Reg No.: 24/0251
Your Reference: SSD-59006709
To: NSW PLANNING & ENVIRONMENT

Feedback on proposed changes to planning controls

Controlled Activity: OLS ENQUIRY
Location: 28-32 BOURKE ROAD ALEXANDRIA
Council: NSW PLANNING & ENVIRONMENT

Drawing Title
WEST ELEVATION

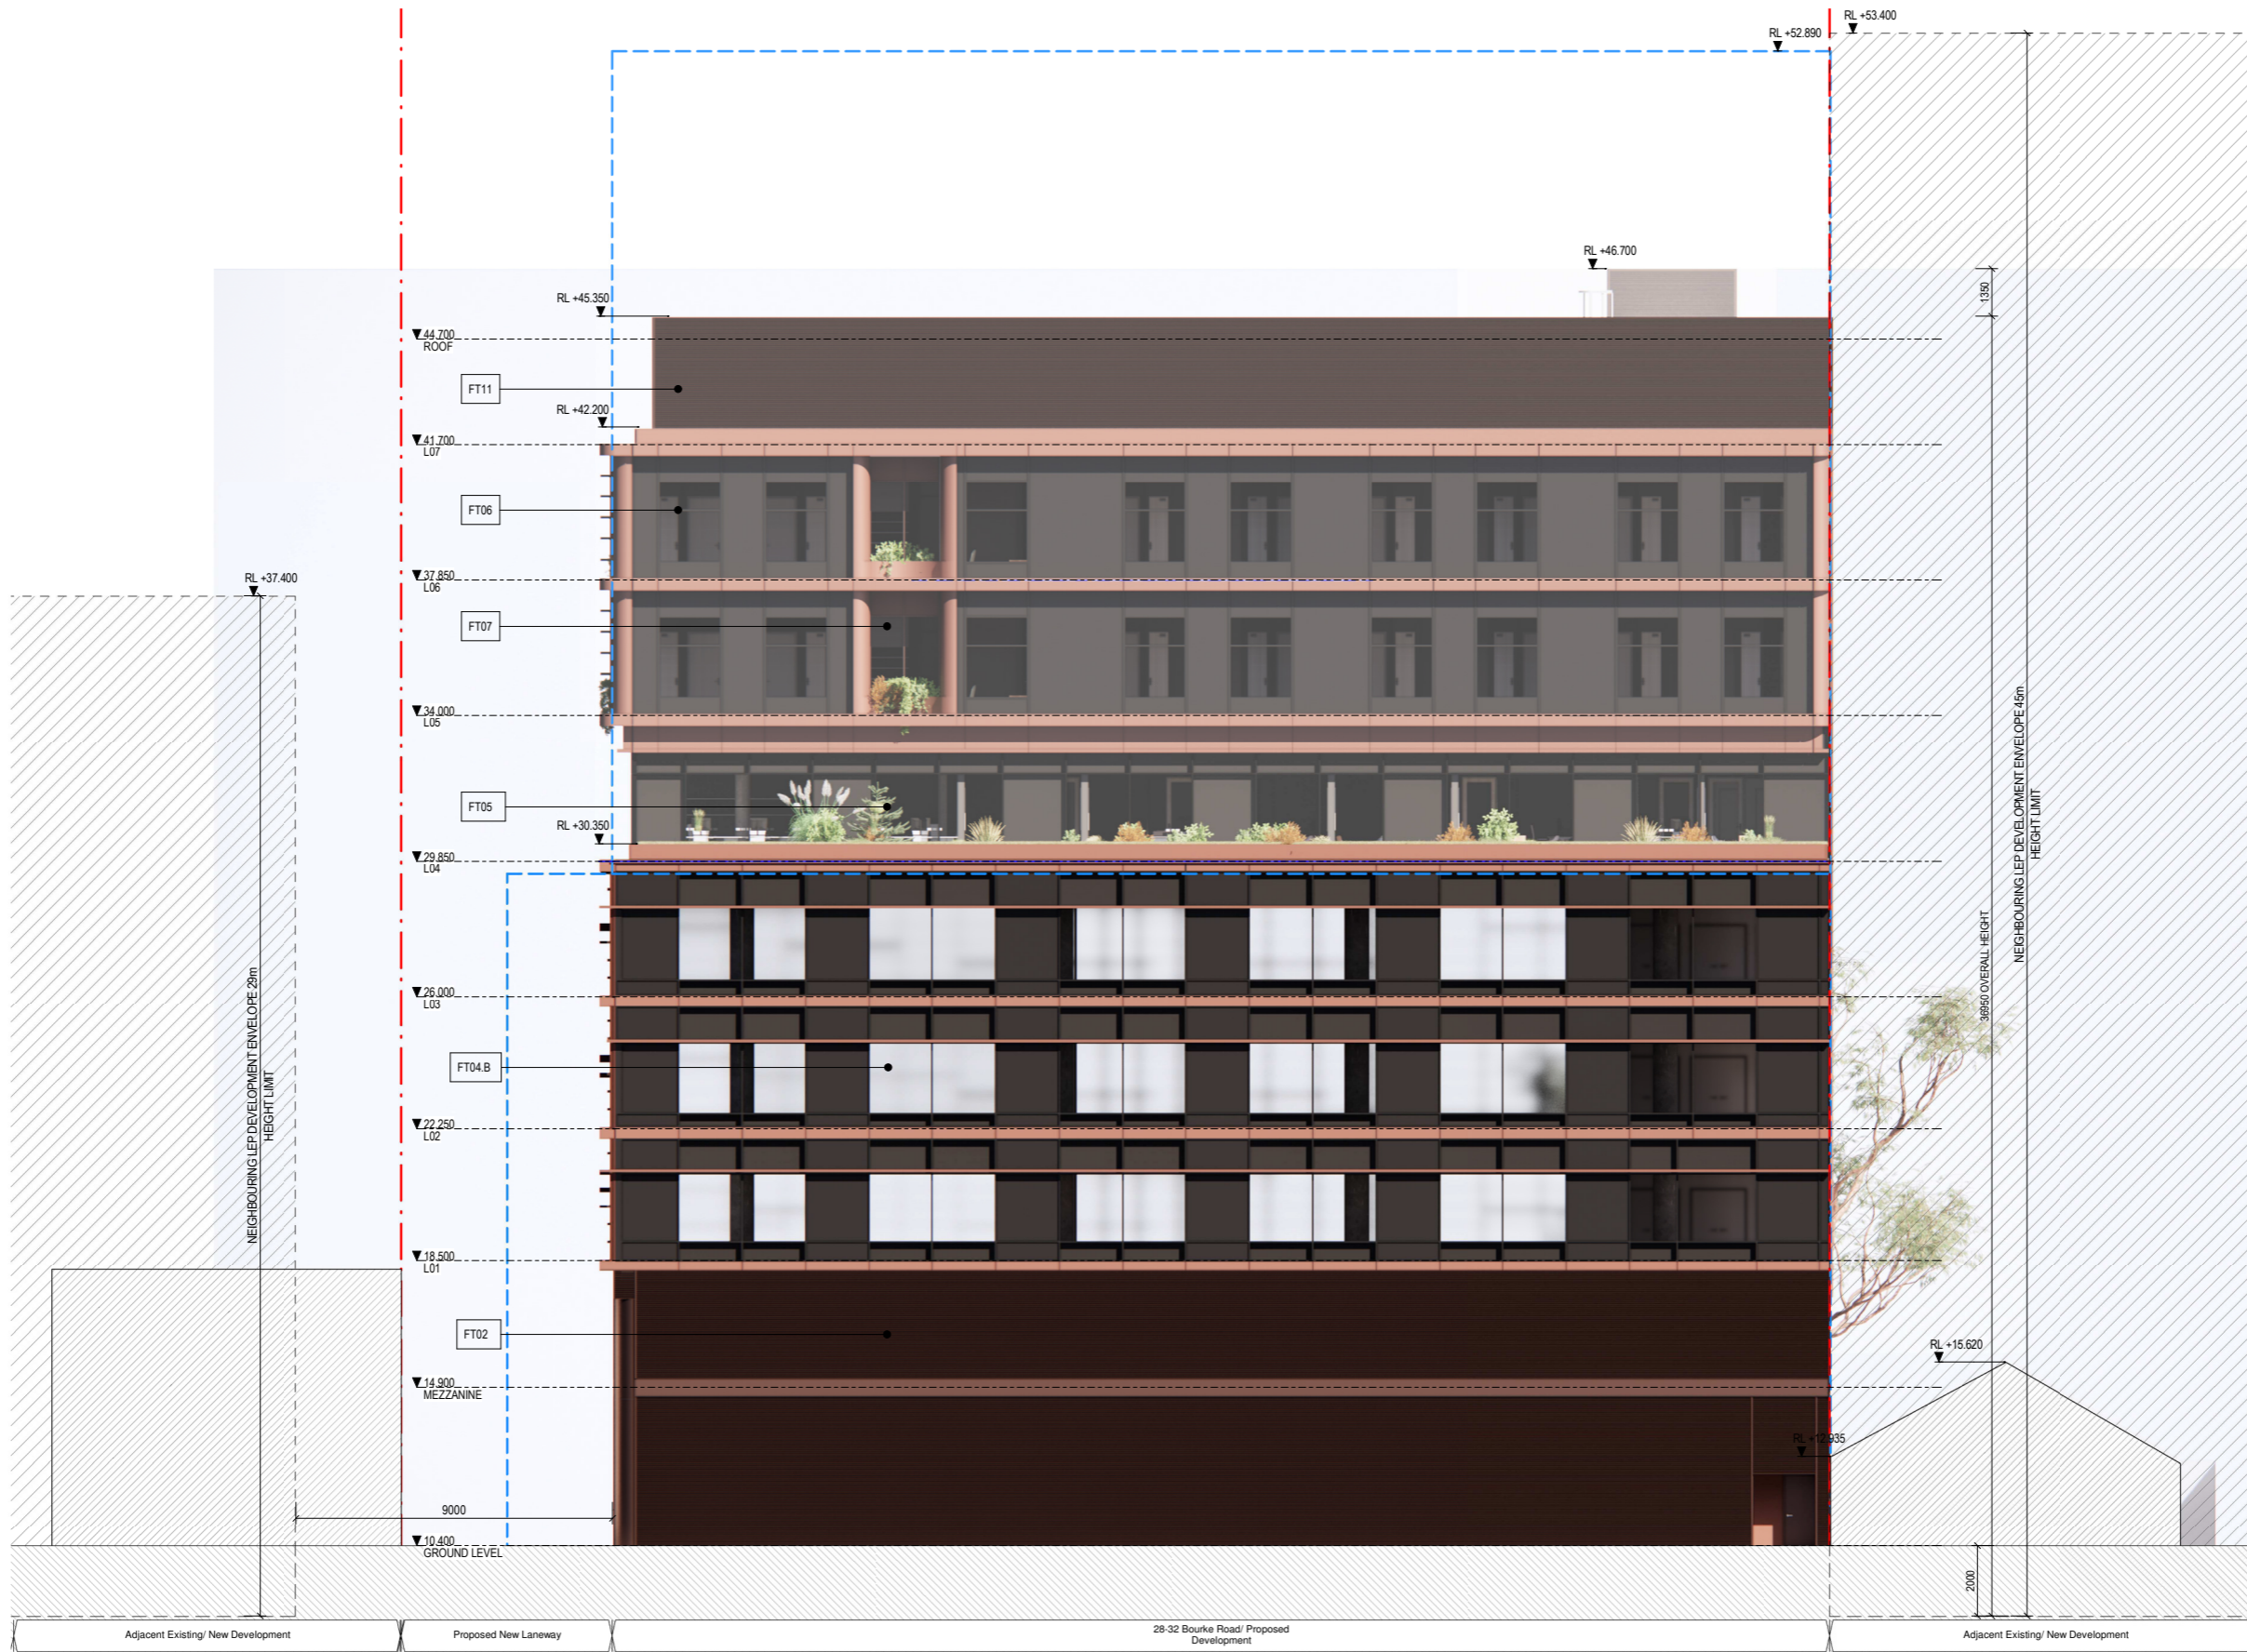
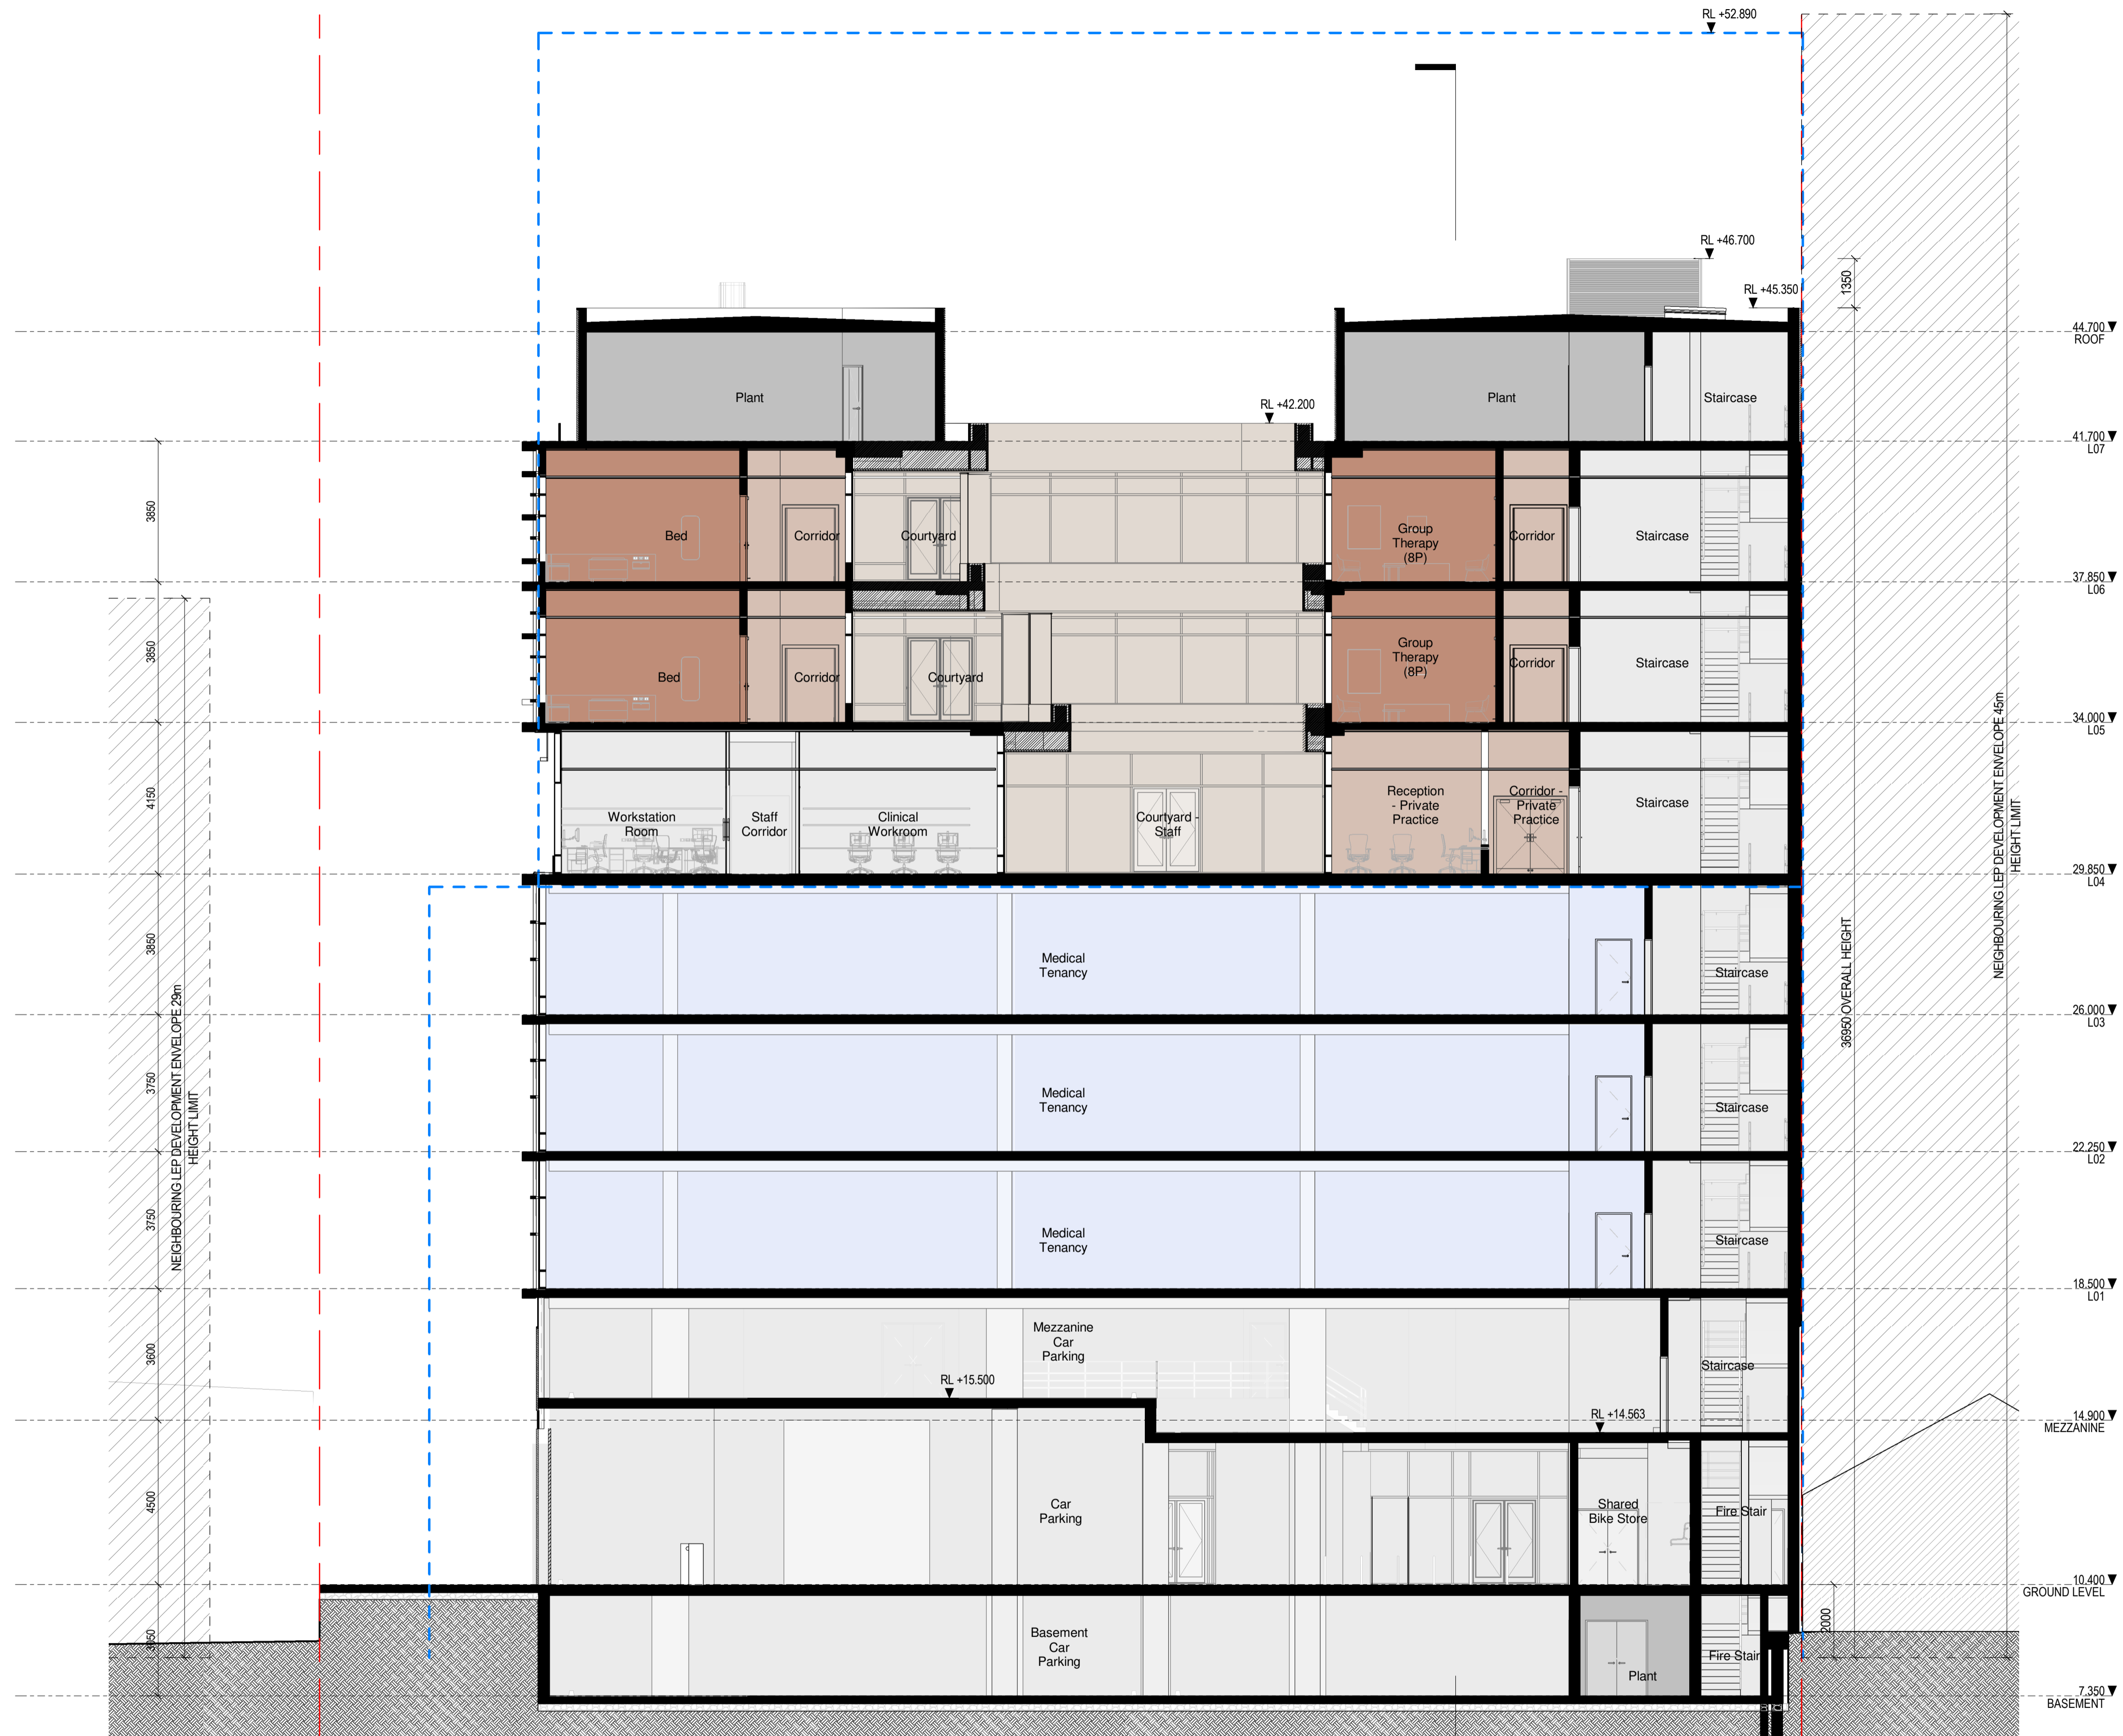
The height of the Obstacle Limitation Surface (OLS) for Sydney Airport over the site is 51m AHD.

I note that the tallest building in the proposed development has a maximum height of 53.41m AHD. Any proposed development designed to be taller than 51m AHD, would be considered a controlled activity and be subject to the Federal Airports (Protection of Airspace) Regulations 1996.

Construction cranes may be required to operate at a height significantly higher than that of the proposed development and consequently, may not be approved under the Airports (Protection of Airspace) Regulations 1996.

Sydney Airport advises that approval to operate construction equipment (ie cranes) should be obtained prior to any commitment to construct.
